From: Jean Fraser
To: Stowe, Barry
CC: Blais, Jason; Long, Steve; Margolis-Pineo, David; Trottier, Dave
Date: 4/22/2013 2:16 PM
Subject: RE: JB Brown, Commercial & Maple
Attachments: Revision Memo Marriott Portland 04-12-13.pdf; C13 Building Elevations MarriottPortland (Revisions) 04-12-13.pdf; C14 Building Elevations MarriottPortland (Revisions) 04-12-13.pdf; C05 Colored Revisions Plan Marriott Portland 04-12-13.pdf

From: Barry Stowe
To: Jean Fraser, Planner
Date: April 12, 2013
Subject: Commercial & Maple Street Mixed Use Development – Revisions

PROJECT: **COMMERCIAL & MAPLE STREET MIXED USE DEVELOPMENT** PORTLAND, ME

COMMERCIAL & MAPLE STREET MIXED USE DEVELOPMENT
PORTLAND, ME
PROJECT: C05
DATE: 10-22-12
SCALE: 1"=20'
DRAWN BY: B.L.B.
SHEET 5 OF 14

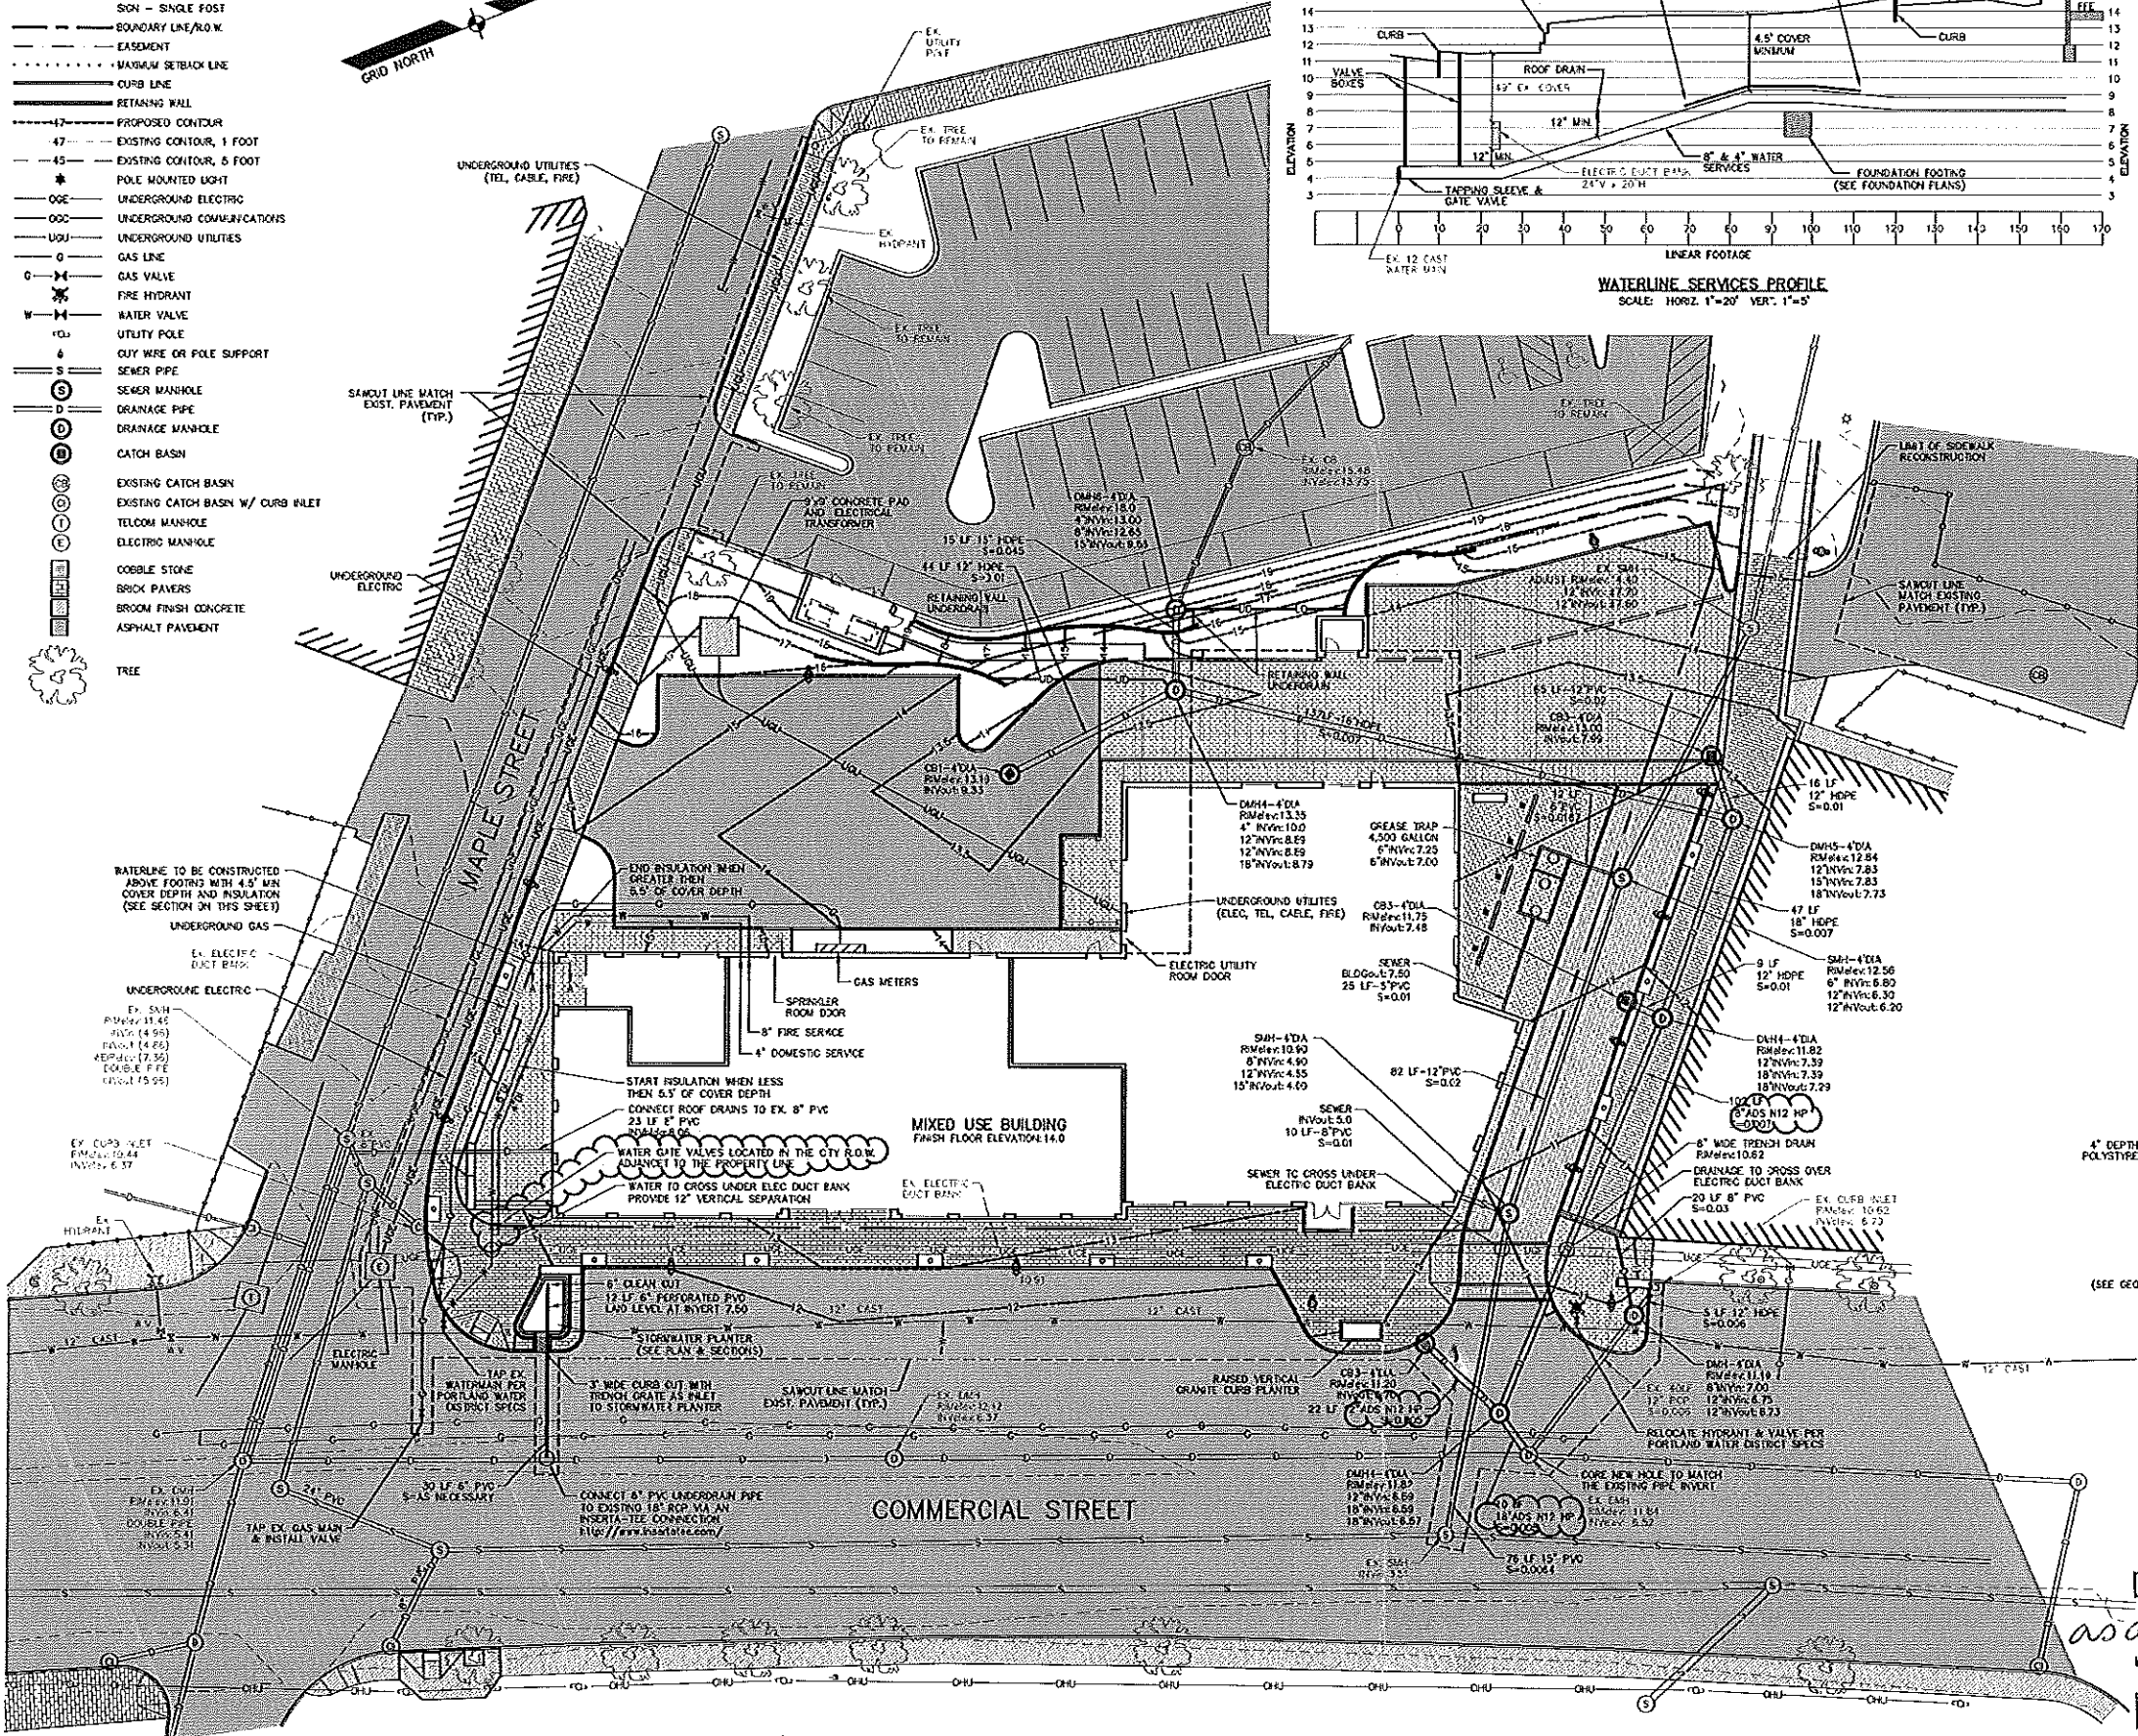
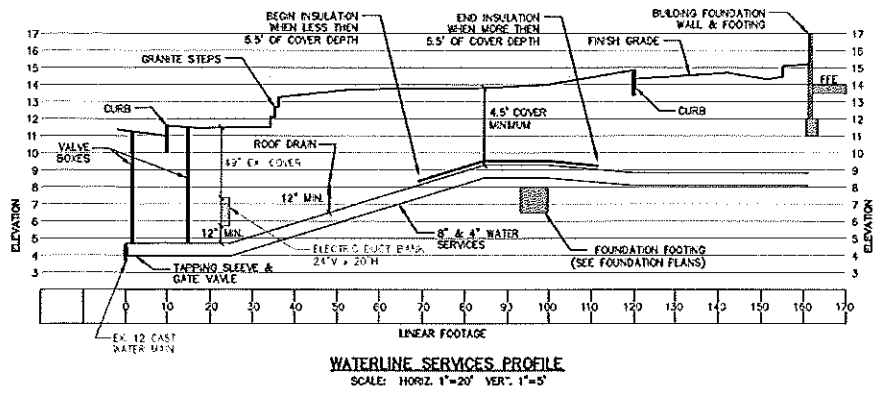
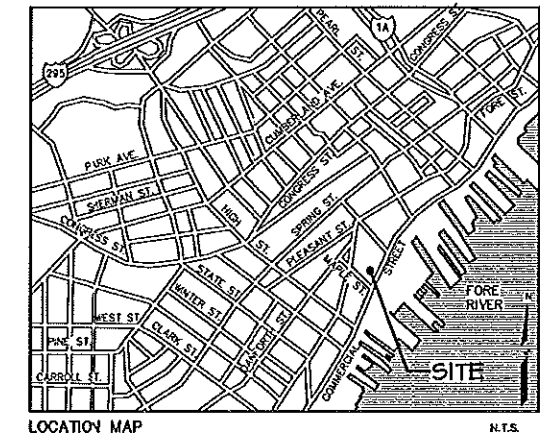
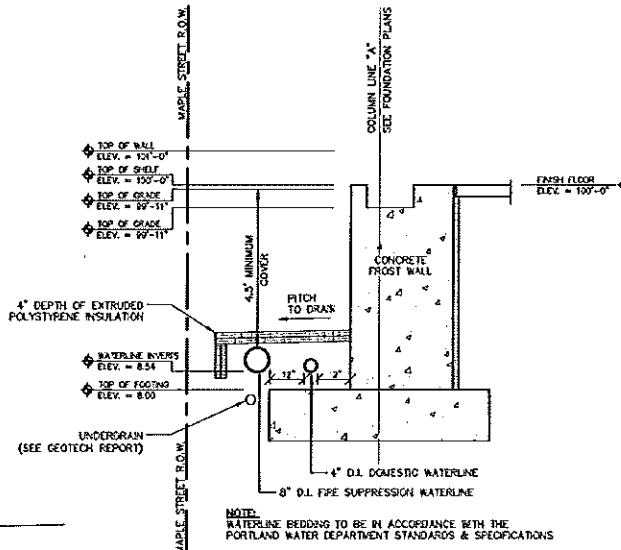
I am writing to confirm that the attached plans are approved subject to revision per your comments in the e-mail below. Please send (pdf OK) a revised CO5 with the pipe reference changed, and a note re ADA compliance of sidewalks added, and I will then stamp and circulate it to inspectors/records along with C13 and C14 to document the amendments.

1. (re 7 on your list) The proposed "HDPE" Drainage pipe for storm drain pipe connections within the City Right of Way is not an allowable pipe material in City streets (OK on your site). Anywhere that a storm drain pipe extends into the City Street, the pipe material will need to comply with the acceptable materials listed in Technical Manual 2.5.2.
Gorham Sand and Gravel is aware of the City requirements for pipe specifications and will be using the ADS N-12 HP meeting the minimum PS of 46. Attached are the pipe specifications. The pipe is a HDPE pipe so I will keep my plan labels the same. However, I'm going to add a note to the plan saying that all work within the ROW shall meet the City of Portland Technical Standards.

3. (Re 3 on your list) Re the water connection valves- what is shown is not the usual and I am waiting for some possible further comments from the Fire Dept on the hydrant relocation and water valves.

-  (3) The waterlines services were revised per the request of the Portland Water District. The proposed water services now remain completely on the property and the gate valves have been move further away from the stormwater planter. In addition, a profile and section has been added to sheet C5 to assist PWD with their review.

Also, the proposed fire hydrant has been moved to a different location. The Portland Water District requested greater horizontal clearance from the tree planter.

-  (4) It was realized that the previously shown existing gas main in Commercial Street is abandoned. The correct gas main is now shown on the plans. Accordingly, the gas service to the proposed building was revised.

-  (6) As a result of the gas main location, it was necessary to revise the proposed sewer main at the intersection of Foundry Lane and Commercial Street. The proposed sewer manhole was deleted and the proposed sewer pipe will now be constructed the existing manhole in Commercial Street.

-  (7) As a result of the gas main location, it was necessary to revise the proposed drainage at the intersection of Foundry Lane with Commercial Street. The drainage manhole was moved to accommodate the gas line. In addition, the Portland Water District request that the catch basin be moved slightly to provide greater clearance from the waterline.

for the record, I confirm that the proposed changes re the water mains (as you have shown) have been reviewed by the Fire Dept and DPS and are acceptable. I also confirm that Deb Andrews has approved the revised utility door locations (as shown) in the context of the HP approval.
